**Ref 2022/1201**

Description: Erection of three storey building containing 6no studio apartments  
(Outline seeking approval over layout, scale, appearance and means of access)  
(Amended Address)

Site Address: Land adjacent 1-4 Springfield Street, Barnsley, S70 6HH.

ELEVATIONS

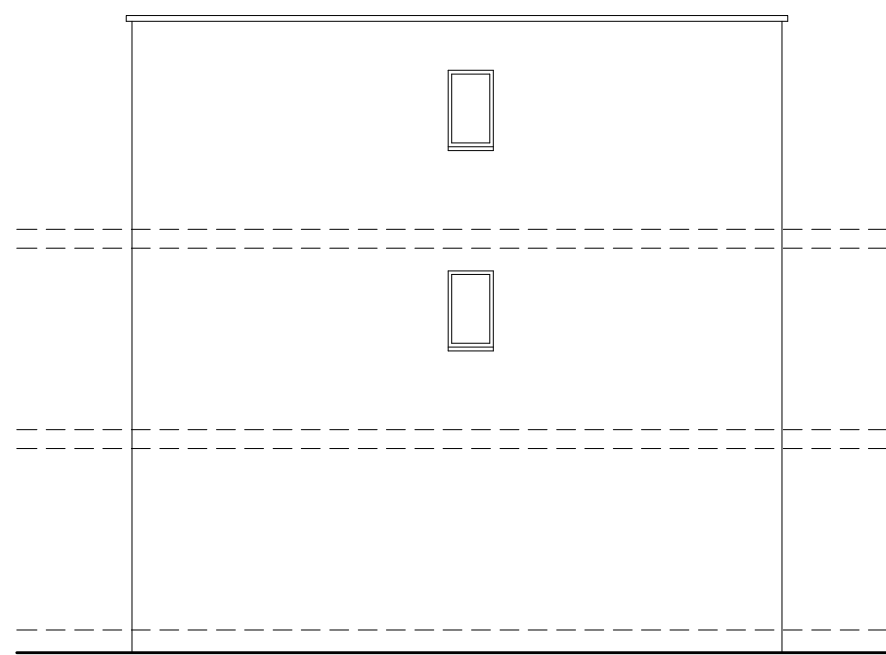
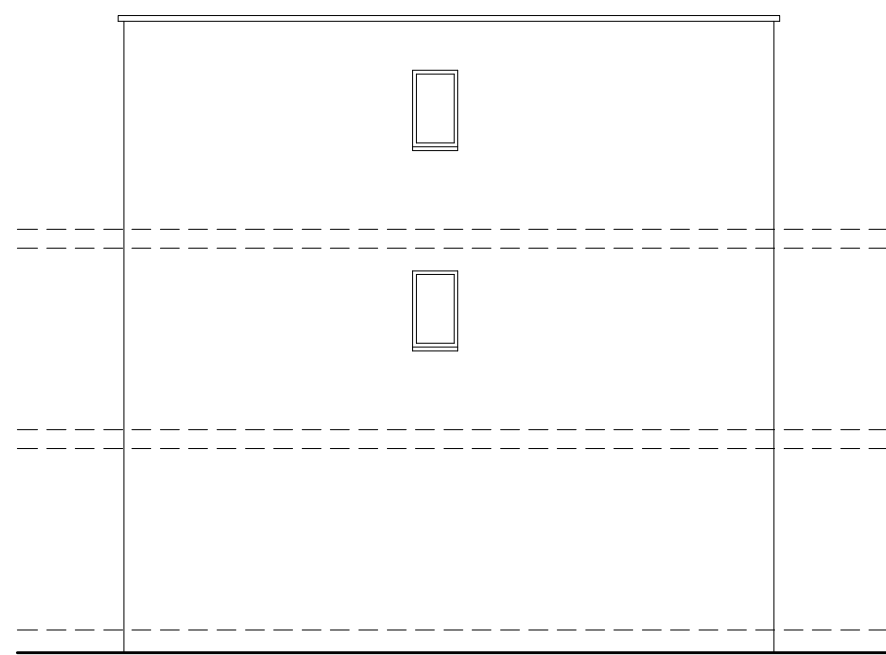
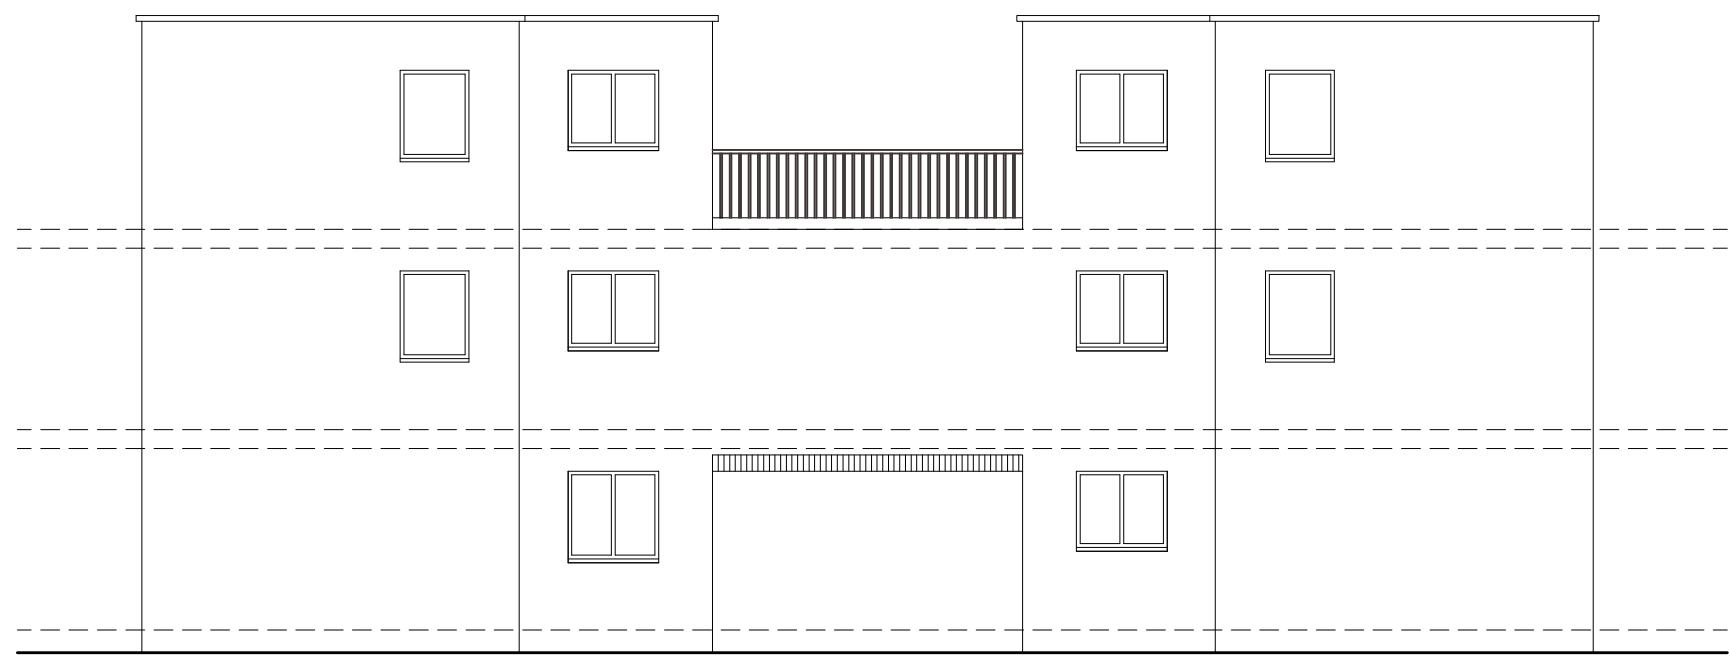
The proposed building would be located very close to the back edge of the footpath and would be in a very prominent position within the streetscene, set further forward than the immediately neighbouring buildings. It is noted that the proposed building would be a similar height to the neighbouring flats, however, they have 2 storeys of accommodation with a pitched roof above (which slopes away from the highway), whereas the proposed building has a full 3 storey of accommodation with a flat roof, as such, it would be more imposing and dominant on the streetscene. In addition, the buildings directly opposite the site have a modest height and are built on a lower level which would exacerbate the height difference.

In terms of design, the proposed building would have fenestration over 3 full floors which is not reflective of the buildings immediately adjacent to the site fronting Springfield Street. It is noted that there are some 3 storey town houses on Springfield Street to the West of the site, however, these are not seen within the same context. Furthermore, the immediately adjacent buildings are relatively traditional in design whereas the proposed building is more contemporary with a boxy, flat roofed design and differing facing materials. This would draw more attention to the building and increase its prominence and dominance within the Streetscene, contrary to the SPD and Local Plan Policy D1.

The neighbouring flats are more modern than a number of other buildings within the immediate area but they do take design cues from the neighbouring properties such as the materials, pitched roof and architectural details around the windows. In addition, since that development was approved design standards have moved on. The proposed building has not drawn from its surrounding and does not respect the immediate area, as such, it would not sit comfortably within the streetscene.

SITE PLAN
SCALE 1:500

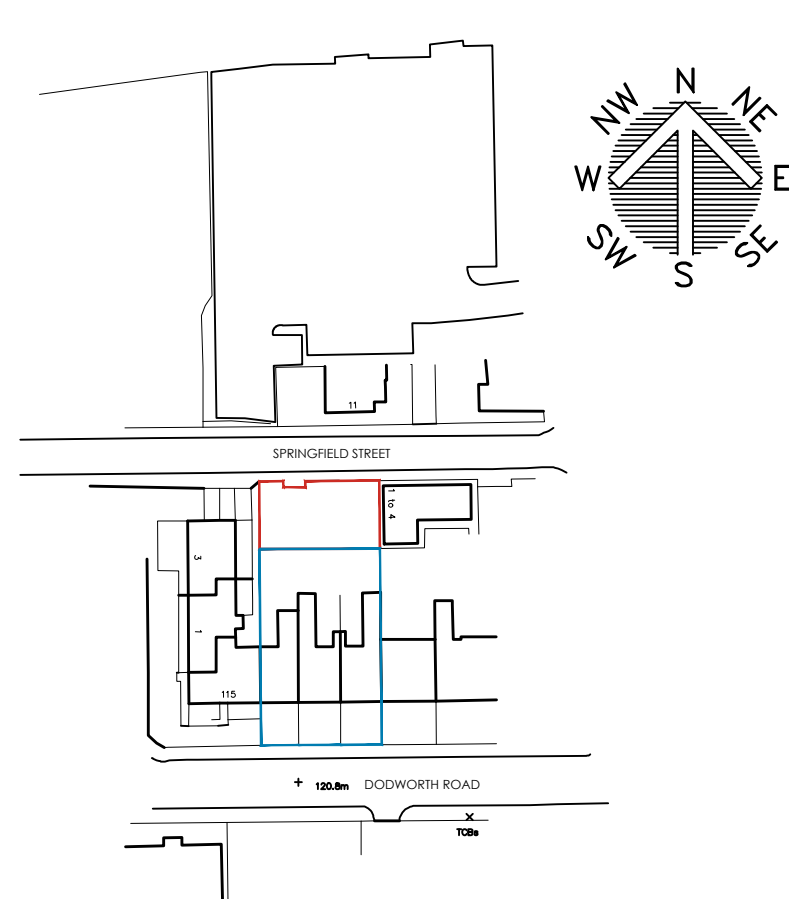
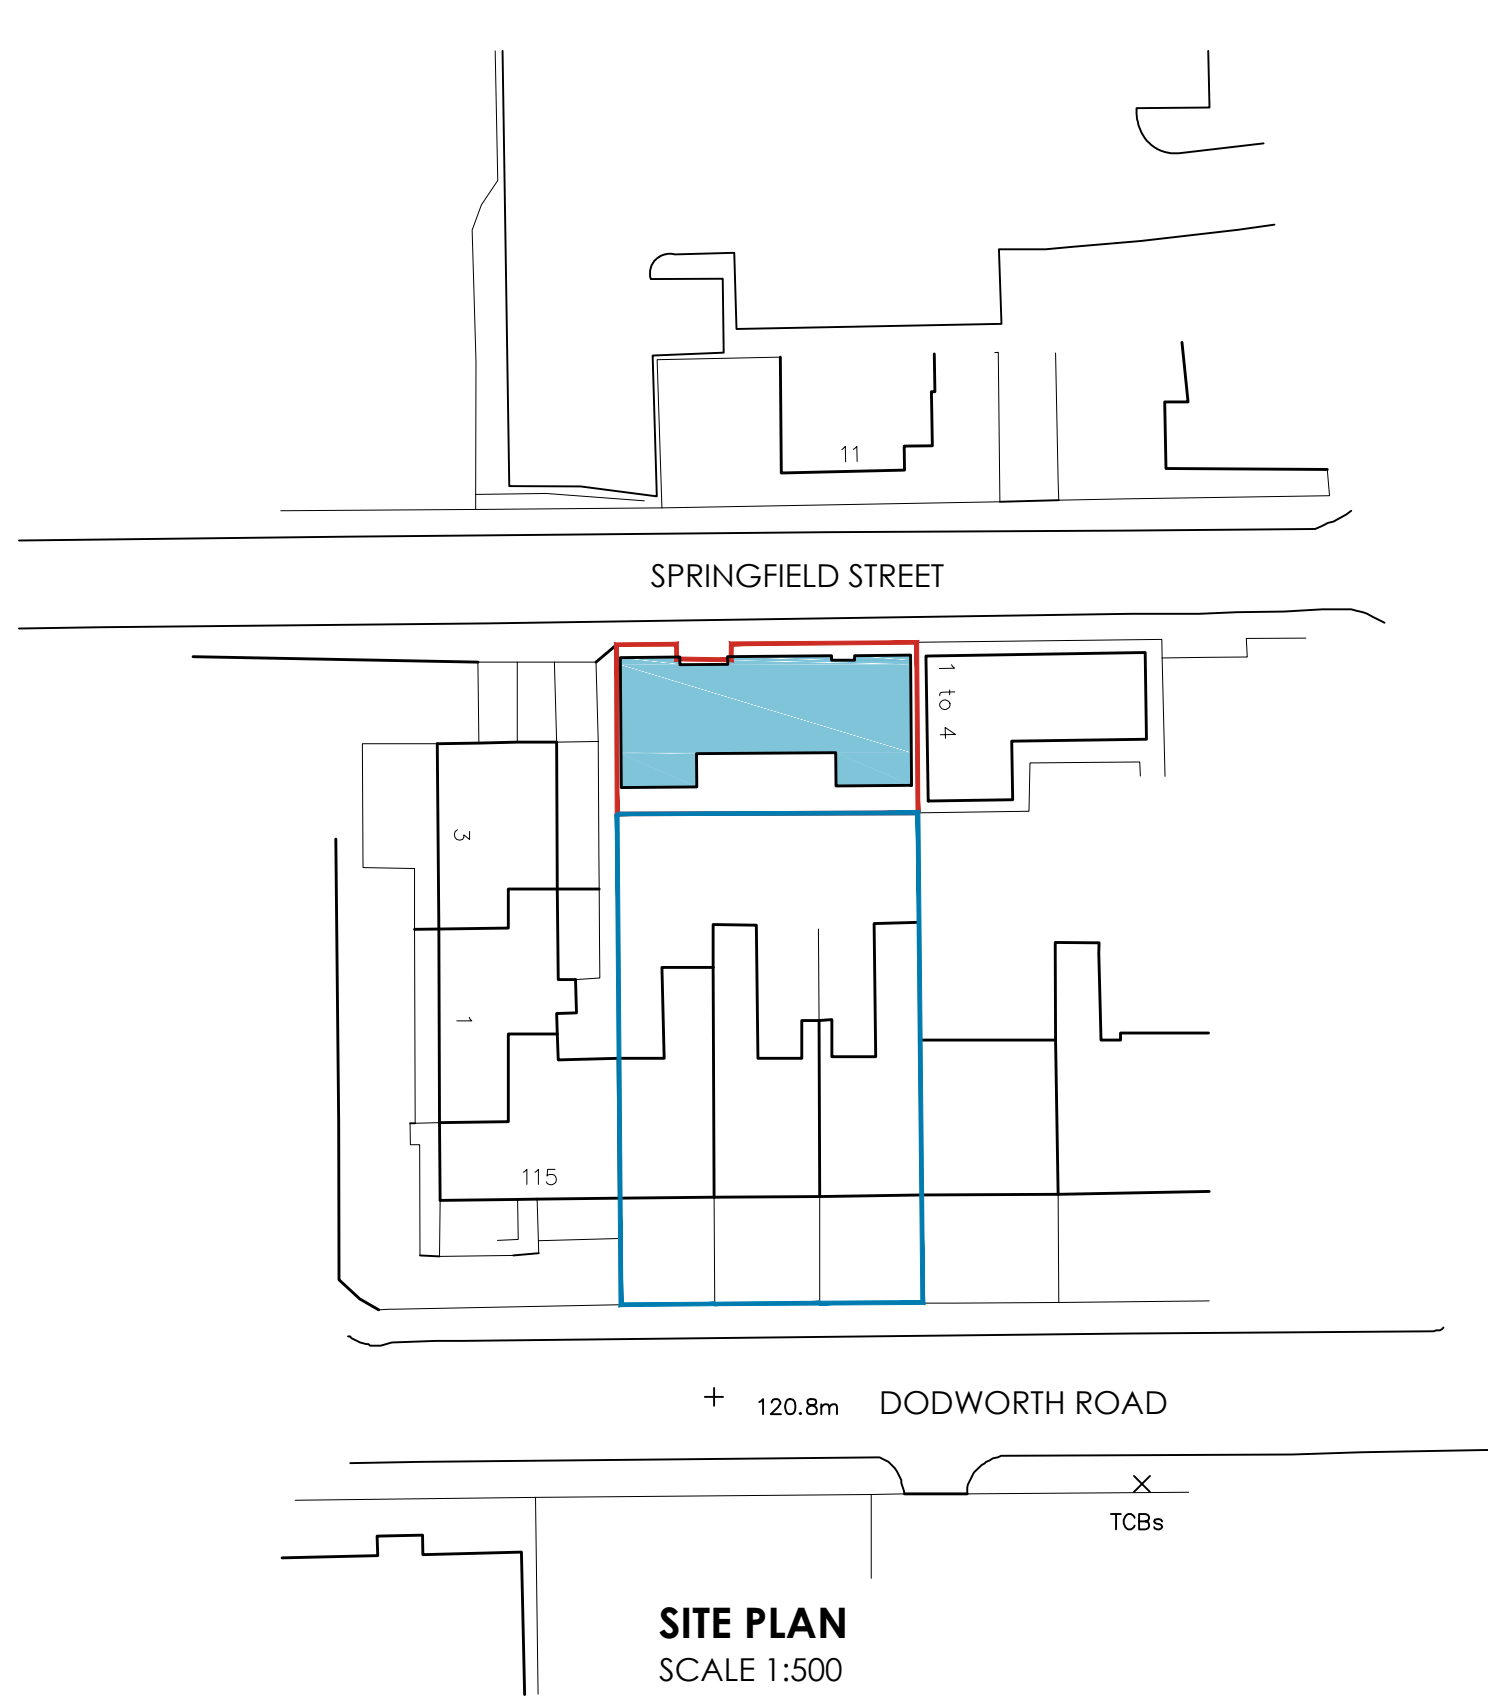
SPD 'Parking' requires 1no. space per unit for dwellings with 2 bedrooms or fewer, however, the plans show only 7no. spaces proposed which is obviously contrary to the SPD. There is also historic parking problems within the area and a lack of on street parking given the double yellow lines to both sides of Springfield Street within the immediate proximity of the site. There is also a residents parking scheme in operation within the area.

As outlined above, the site backs onto 3no properties which front Dodworth Road and have been subdivided into flats. This site, and the area immediately to the rear of those properties, is currently used as parking for the residents. The submitted plans do not show if there would be any retained parking for those residents and how many spaces there would be, as such, they could be a displacement of parking onto the surrounding road network.

The access into and from the site is also less than ideal. The parking would be accessed through the centre of the building. Given the building is proposed adjacent to the back edge of the footpath there would be very limited visibility for drivers when exiting the site which could impact pedestrian safety. There could also be a conflict, due to lack of visibility, if one car is entering and one car is exiting the site.

The parking layout does show provision for cycle parking, which is welcomed, however, there is no provision shown within the site for waste storage which could lead to a reduction in parking space in the future.
